**Transport
for NSW**

**New Grafton Correctional Centre Concept Proposal and Stage 1 Early Works (SSD7413)
Notice of Exhibition**

CD16/11653

TYPICAL CROSS SECTION - AVENUE ROAD

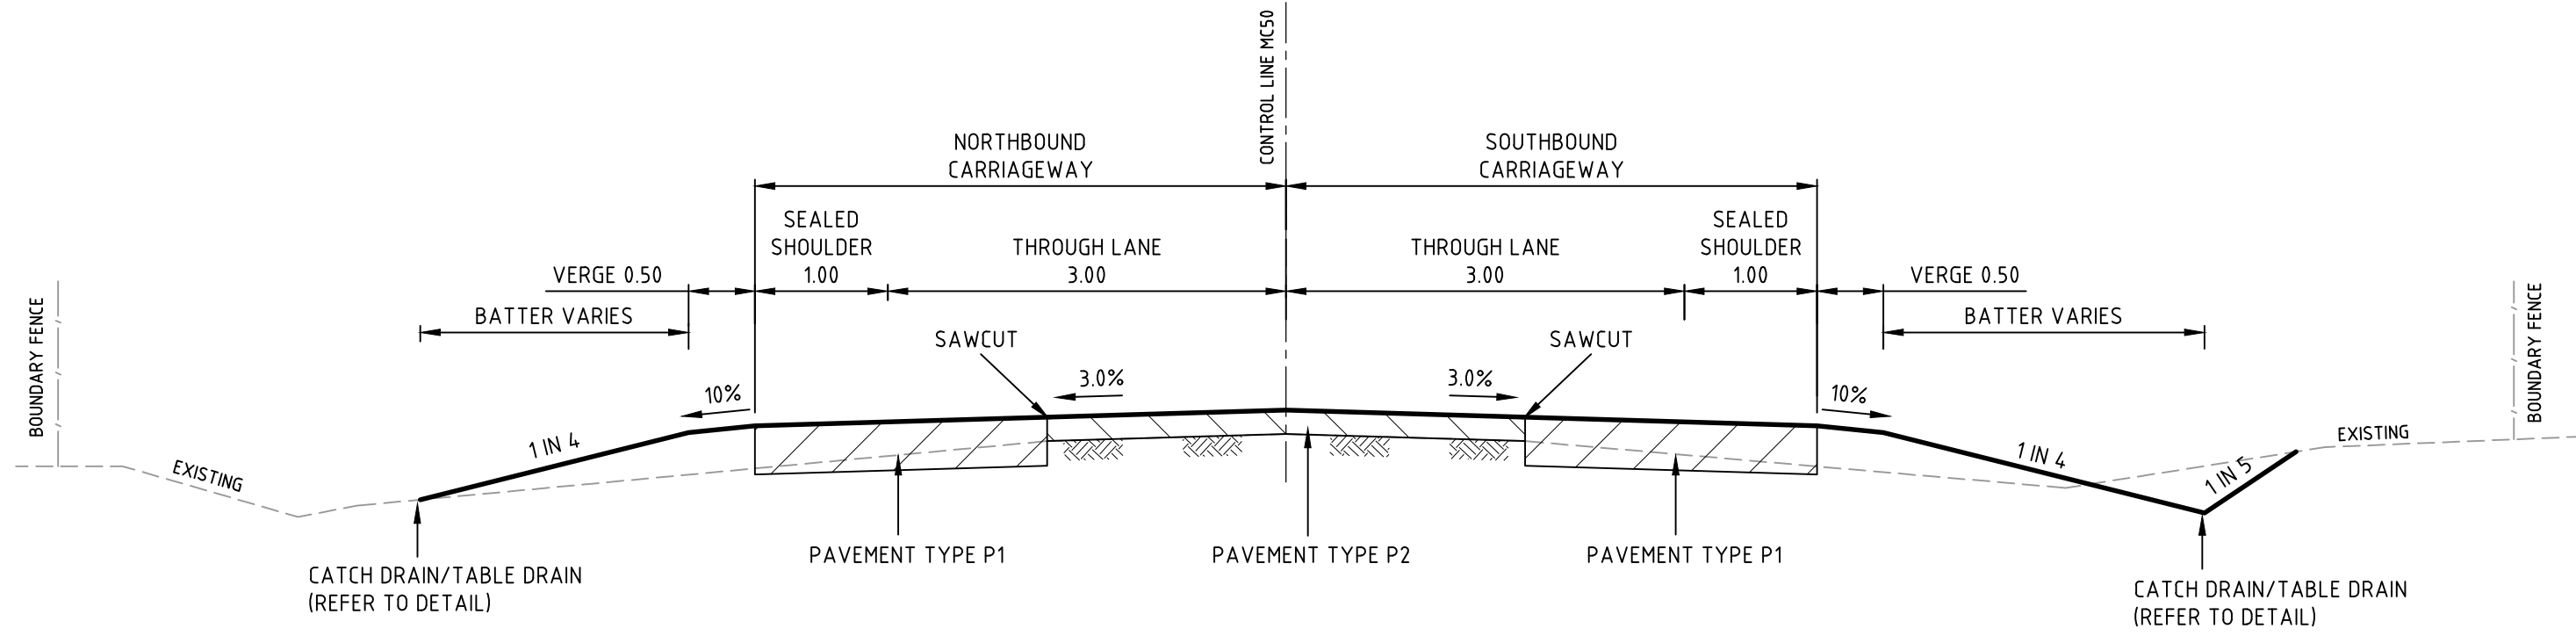
Atwal Bus Service Pty Ltd currently operates via parts of Avenue Road near the proposed location of the Grafton Correctional Facility. Avenue Road is narrow, and may not be fully bus capable at present. However, if road upgrades associated with this proposal were to be provided then a future bus service could be considered to the facility. It would be about 4.5km to divert to the site. There are other routes around Grafton and neighbouring districts which could also be considered for diversion to the site if sufficient demand was evident. An area for a 12.5 metre to turn around, suitable kerbing and a bus shelter would be required. The proponent's support for a potential future bus service to the facility and allowance for the turning bay and bus shelter in the correctional centre design and preliminary earthworks would assist the implementation of this service.

- The experience at Cessnock Correctional Facility is that there is a demand for public bus travel between that facility and Maitland Station. It is considered likely that there will also be demand for a bus service between Grafton Railway Station and the new Grafton facility. The allowance for a future bus shelter and bus turning circle sufficient for the turning circle of a 12.5 metre bus use could be considered as part of the excavation works for Stage 1.

AVENUE ROAD DETAIL PLAN

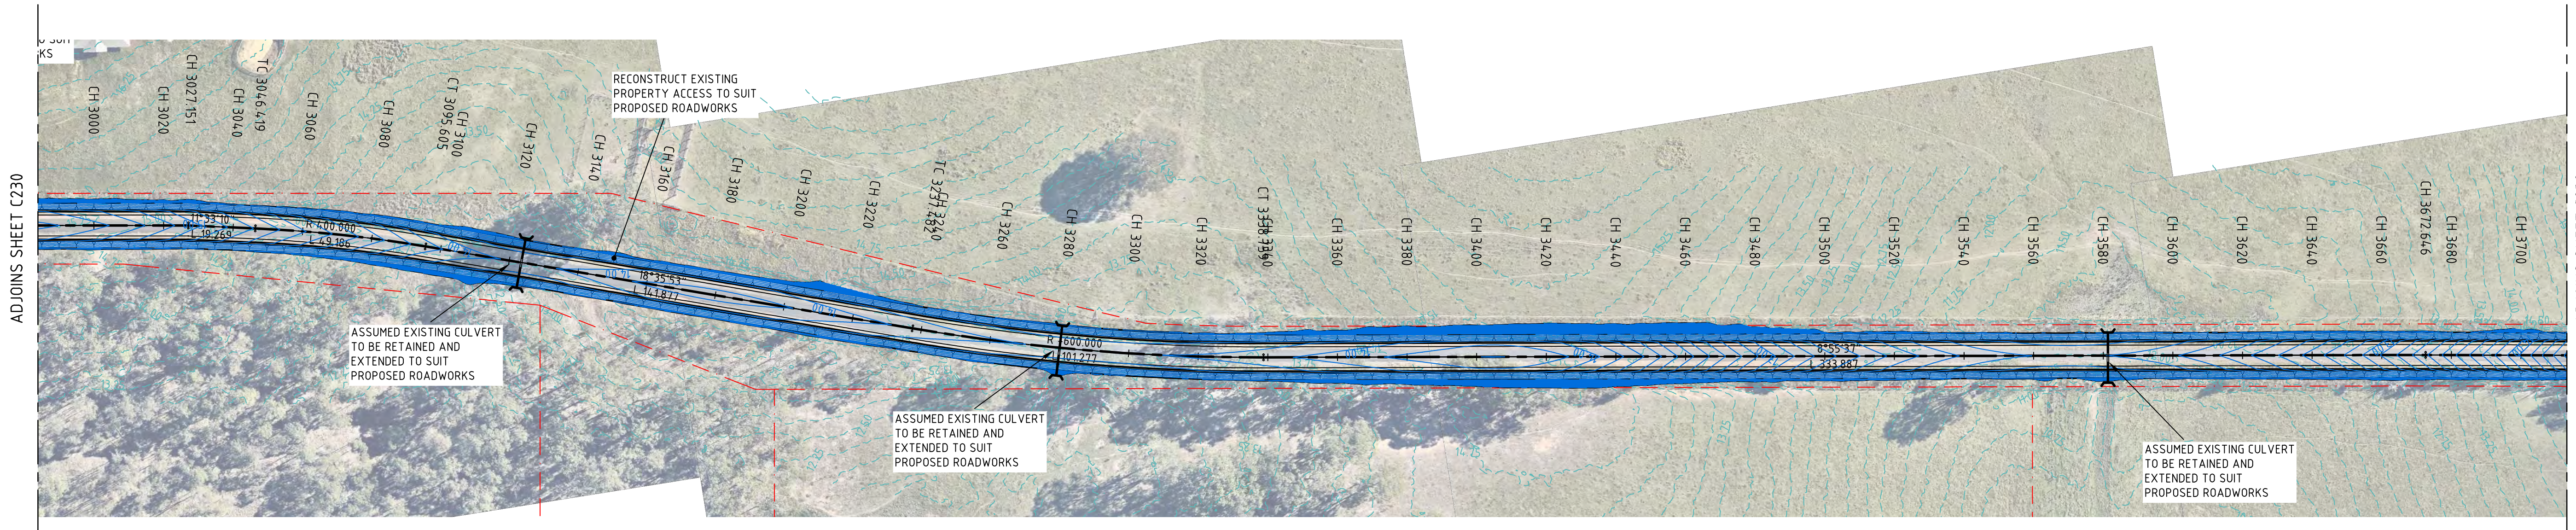
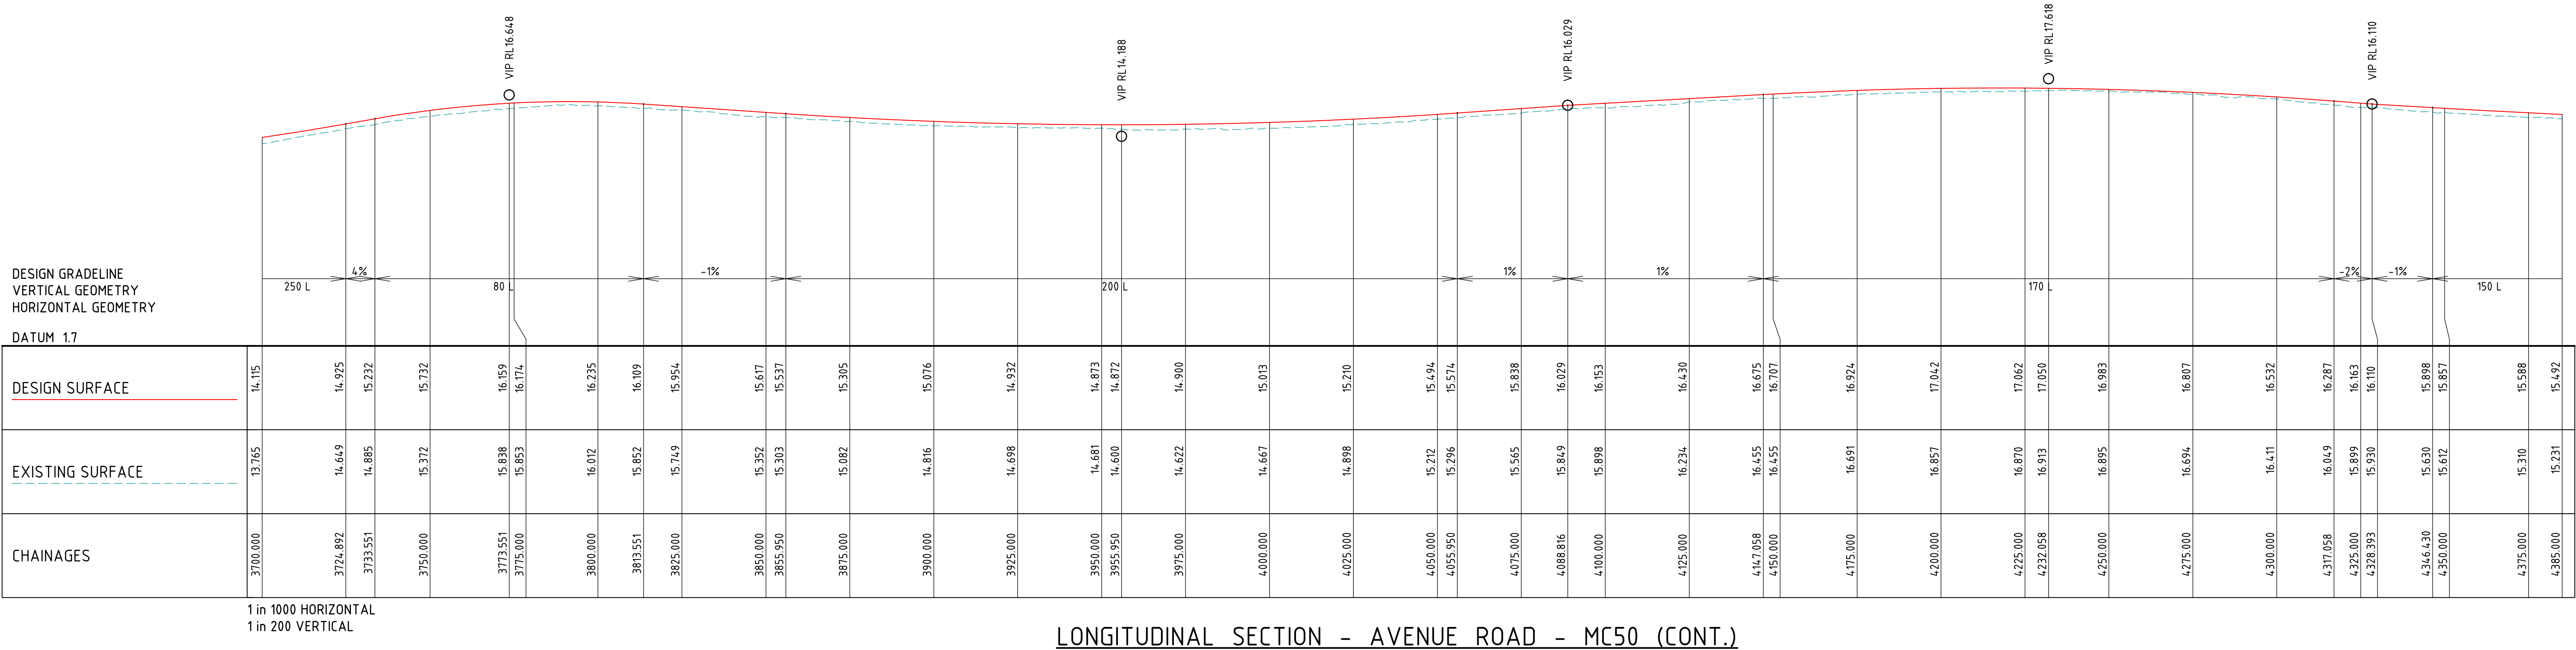
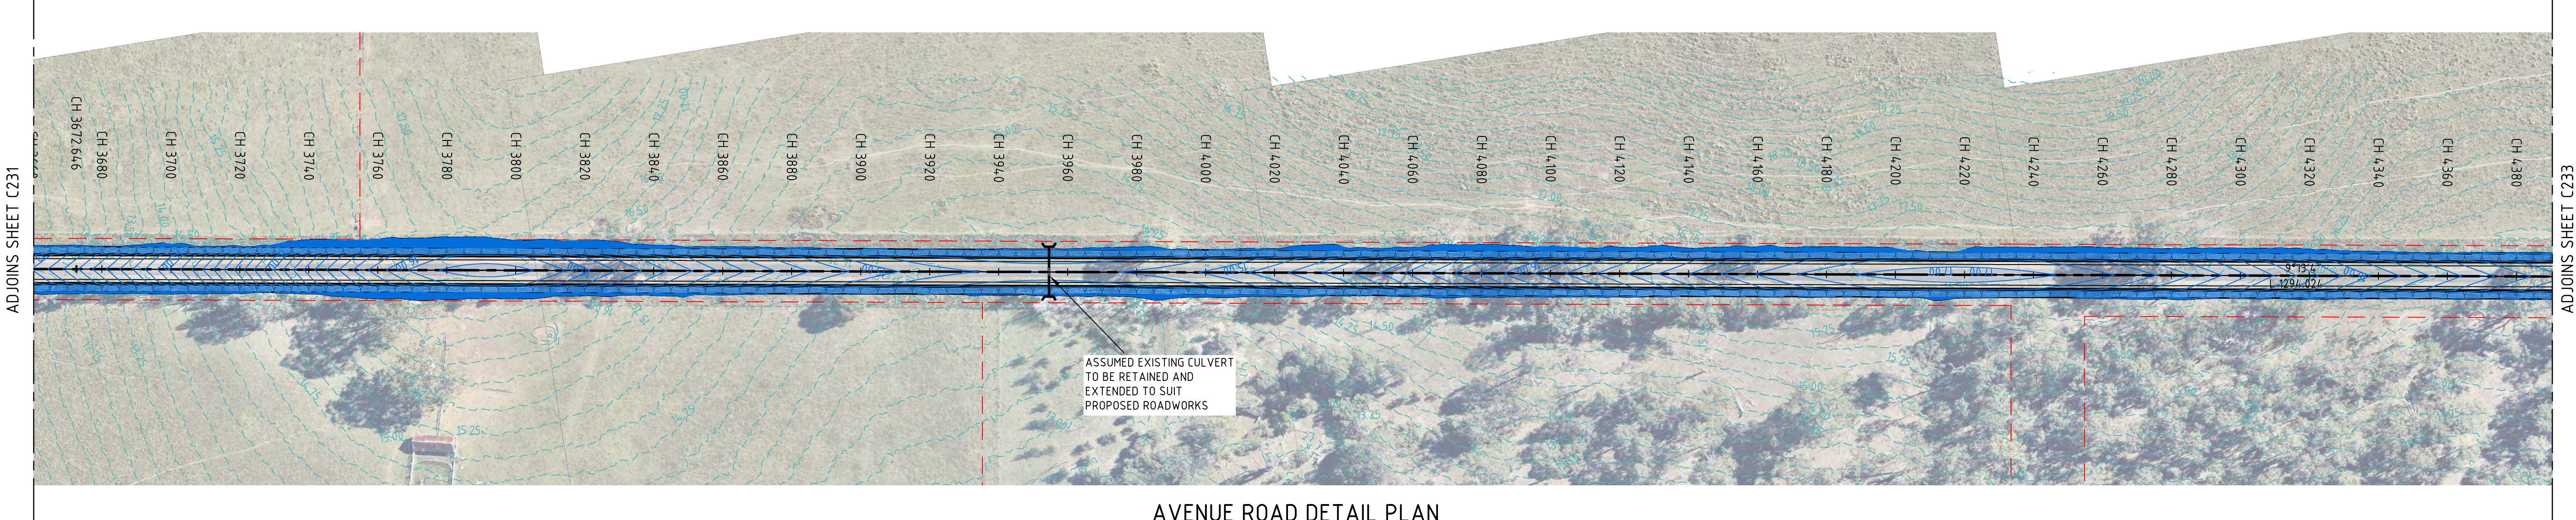
It is noted that some sections of the access roads to the proposed correctional centre are narrow for two way movements and road side objects are located within the clear zone. The existing arrangement would have potential to increase crashes along access roads to the proposed correctional centre with the increase in number of vehicle movements generated from the proposed development.

It is noted that the some sections of the access roads are to be upgraded to provide passing bays.

Based on the results of the road safety audit, the applicant needs to minimise the safety risks along the access roads to the proposed correctional centre and review the design drawings for the proposed upgrades and implement safety measures as required.

The proposed road upgrade be designed in accordance with the relevant Austroads Road Design Guide.
